Application for a non-material amendment following a grant of planning permission.

Number	
Suffix	
Property name	Sunny Corner
Address line 1	Copse Lane
Address line 2	
Address line 3	
Town/city	Walberton
Postcode	BN18 0QH
Description of site location must be completed if postcode is not known:	
Easting (x)	496503
Northing (y)	106526
Description

9 No. dwellings with associated car parking, bin storage & landscaping & creation of new access road from existing access onto West Walberton Lane. This application is a Departure from the Development Plan

Reference number:	APP/C3810/W/18/3210153
Date of decision	06/06/2019

Drawing title
Plot 9
--
Plans & Elevations

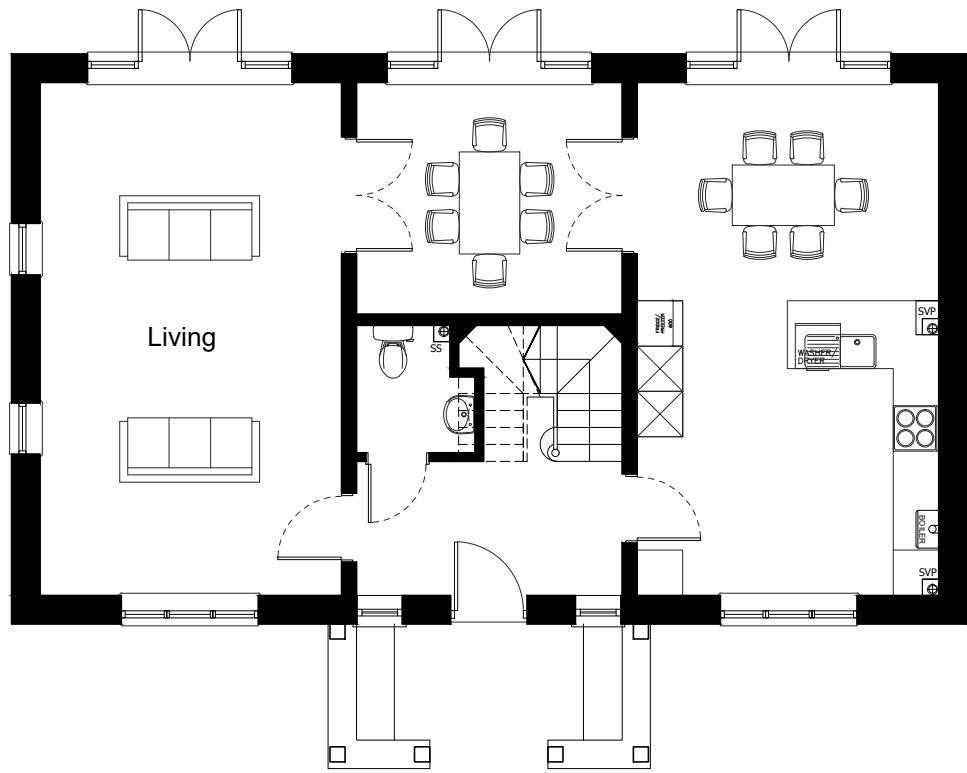
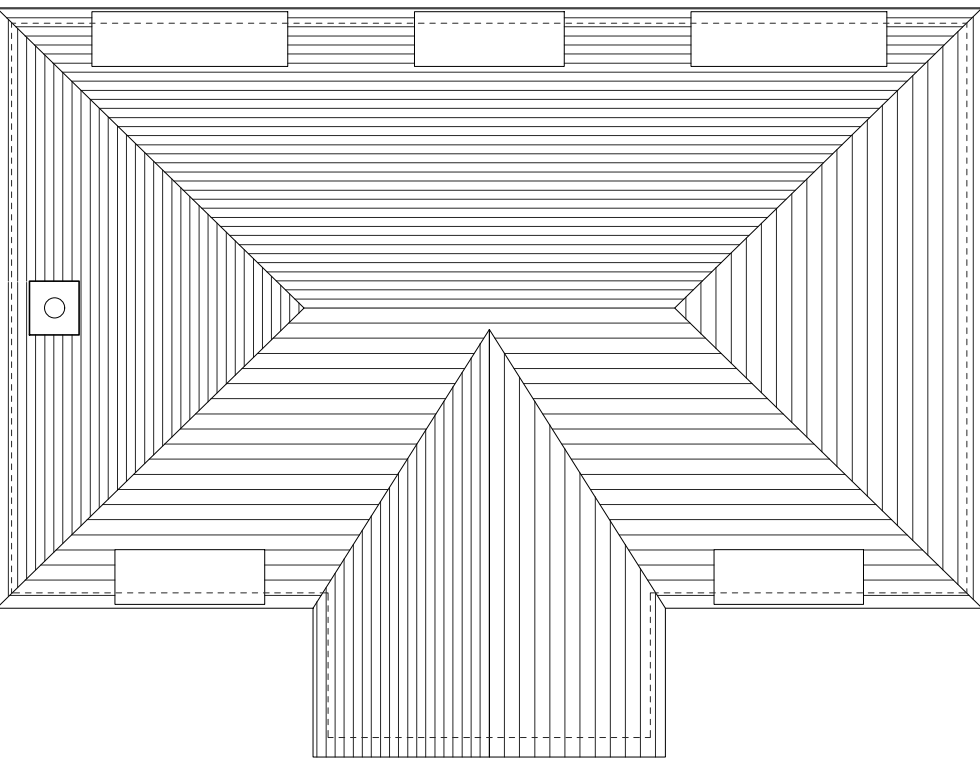
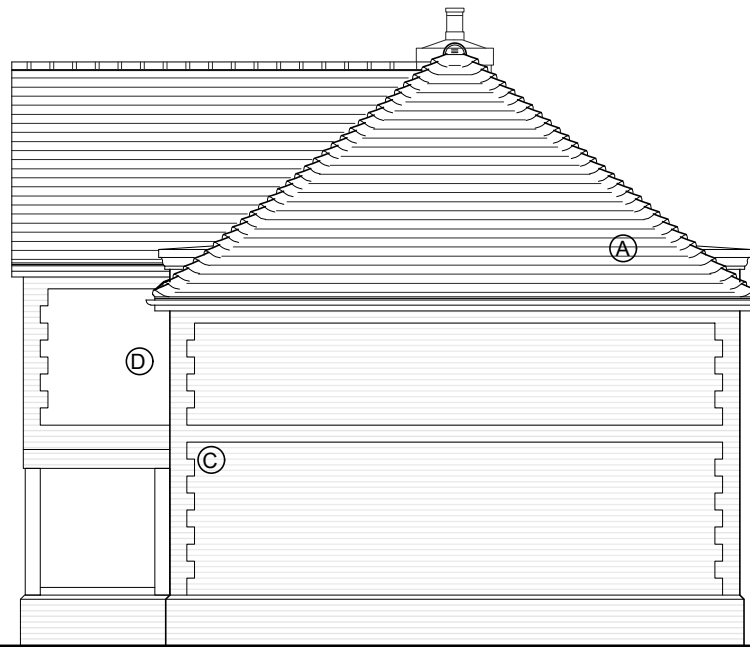
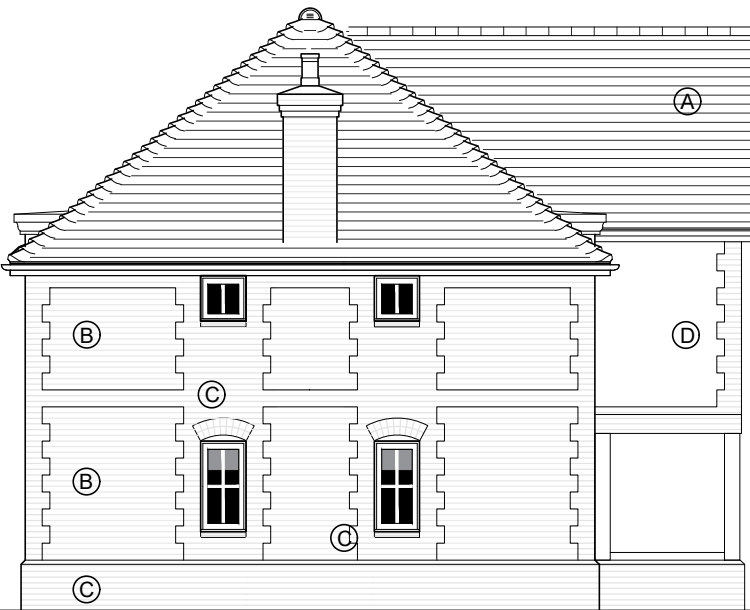
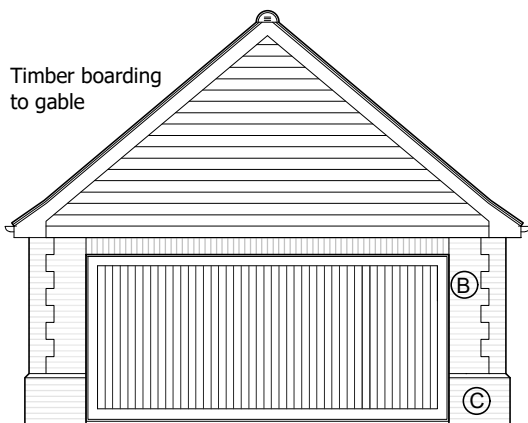
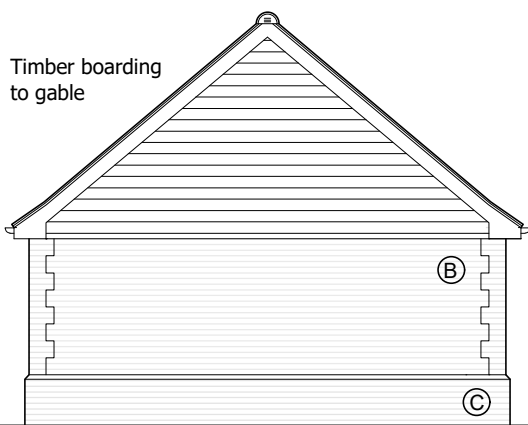
PLOT 9 - Alteration of chimney; replace bifold doors to rear with French doors and sidelights

17-025/0017 REV P7 - Plot 9
